**WELWYN HATFIELD BOROUGH COUNCIL
ASSISTANT DIRECTOR (PLANNING)**

DELEGATED APPLICATION

Application No: 6/2022/2787/HOUSE
Location: 23 Kingswell Ride Cuffley Potters Bar EN6 4LH
Proposal: Erection of single storey side extension
Officer: Ms Kirsty Shirley

6/2022/2787/HOUSE

DRAWING TITLE: **Proposed Ground Floor**

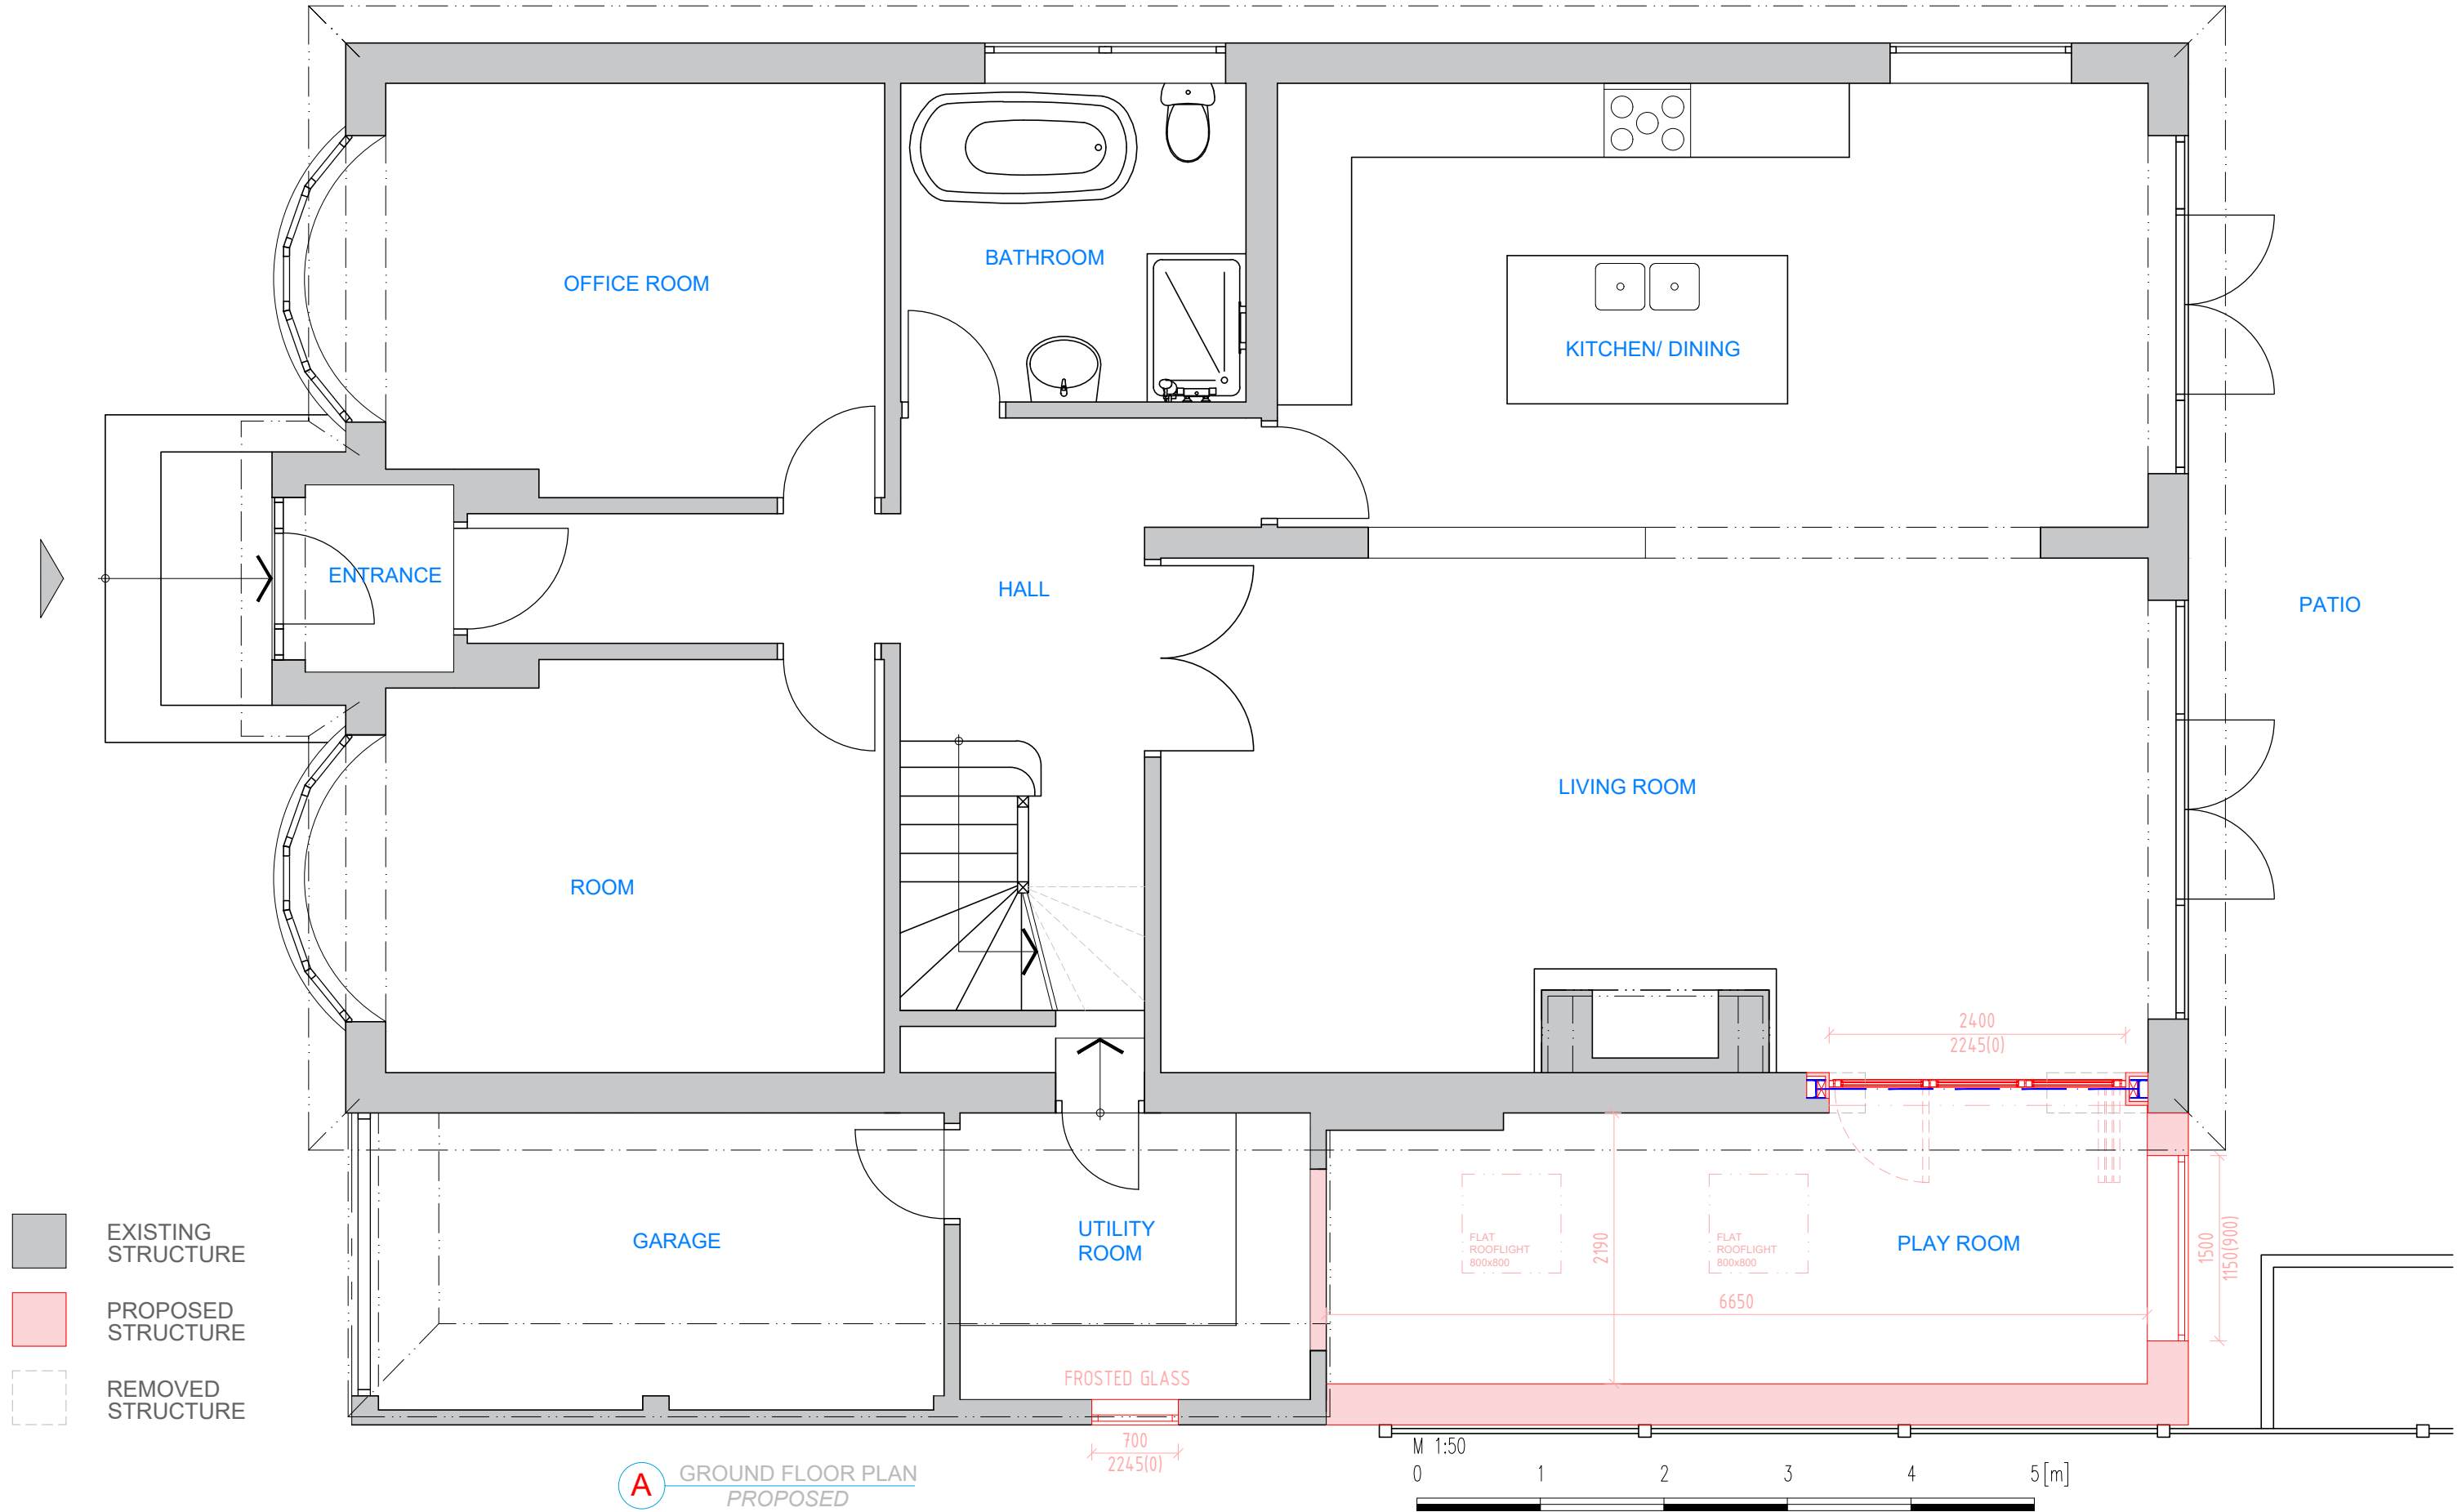
Comment (if applicable):	
Would the development reflect the character of the area?	
<input checked="" type="checkbox"/> Yes <input type="checkbox"/> No	
Comment (if applicable): The proposed side extension would be positioned behind the existing single storey side projection and would finish in line with the rear elevation of the dwelling, infilling the current space. The positioning and scale of the extension would appear subservient towards the application dwelling. The roof of the extension would project above the garage, allowing for partial views of the extension from the street scene. The roof form of the extension would match the roof form of the garage and matching materials can be secured by condition to ensure that the development remains in keeping with the appearance of the dwelling and character of the wider area.	
Would the development reflect the character of the dwelling?	
<input checked="" type="checkbox"/> Yes <input type="checkbox"/> No <input type="checkbox"/> N/A

DRAWING TITLE: **Proposed Elevations**

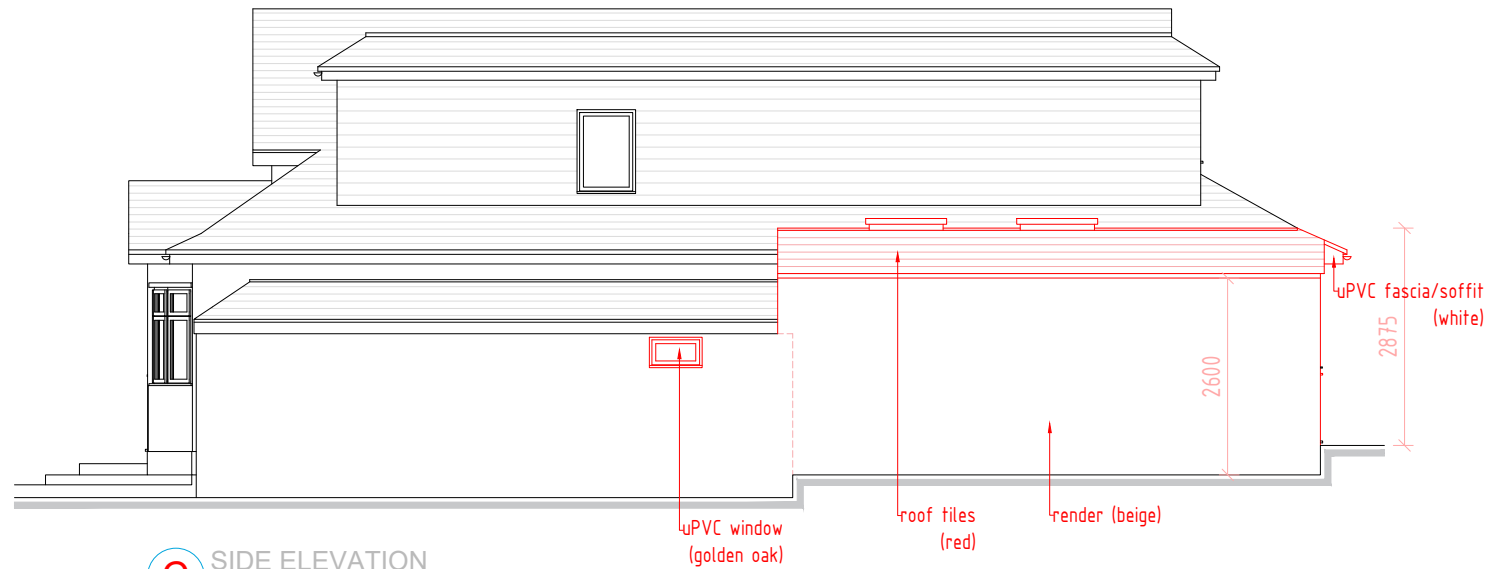
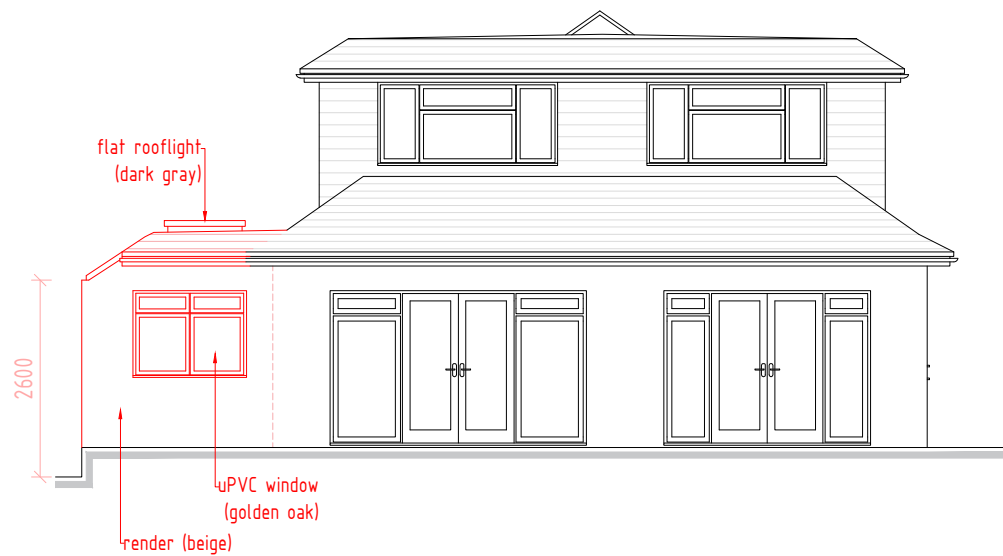
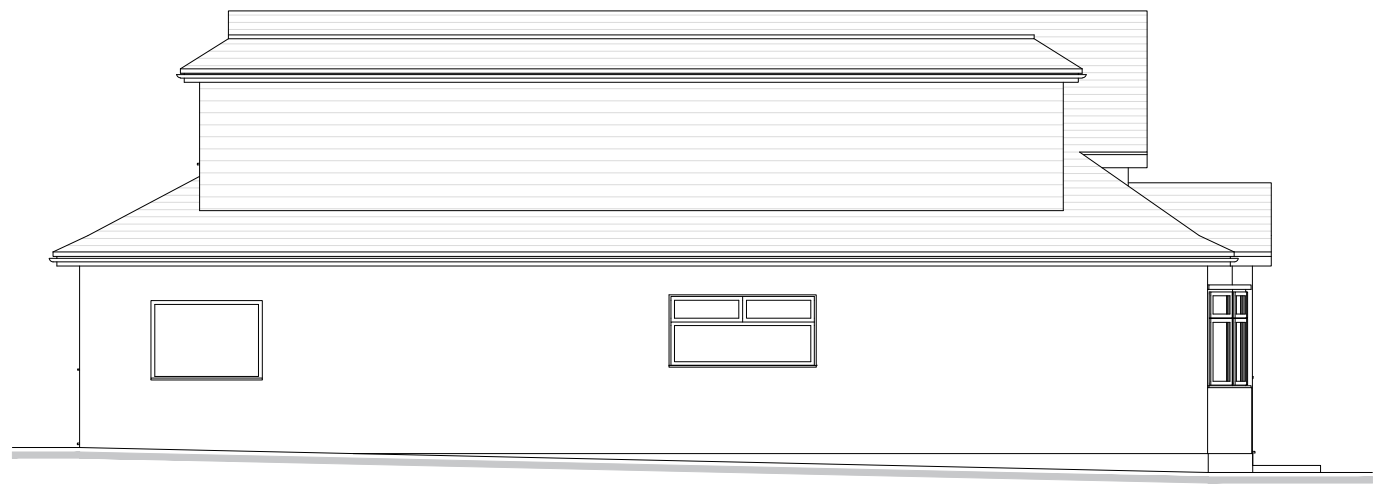
Comment (if applicable): No neighbour representations have been received. The scale and positioning of the development would not result in adjoining neighbours to experience an undue loss of light nor would the development appear overbearing or unduly dominant. In terms of privacy, a modest sized window would be inserted into the ground floor flank elevation facing towards adjoining neighbour No. 21. The window would serve a non-habitable space and can be conditioned to be obscured glazed to maintain the privacy of the occupiers of No. 21. A window would also be inserted into the rear elevation of the extension, but no neighbours adjoin the rear of the application site.	
Would the development provide / retain sufficient parking?	
<input checked="" type="checkbox"/> Yes <input type="checkbox"/> No <input type="checkbox"/> N/A

1. The brickwork, roof tile, bond, mortar, windows, detailing, guttering, soffits and other external decorations of the approved extension must match the existing dwelling in relation to colour and texture.
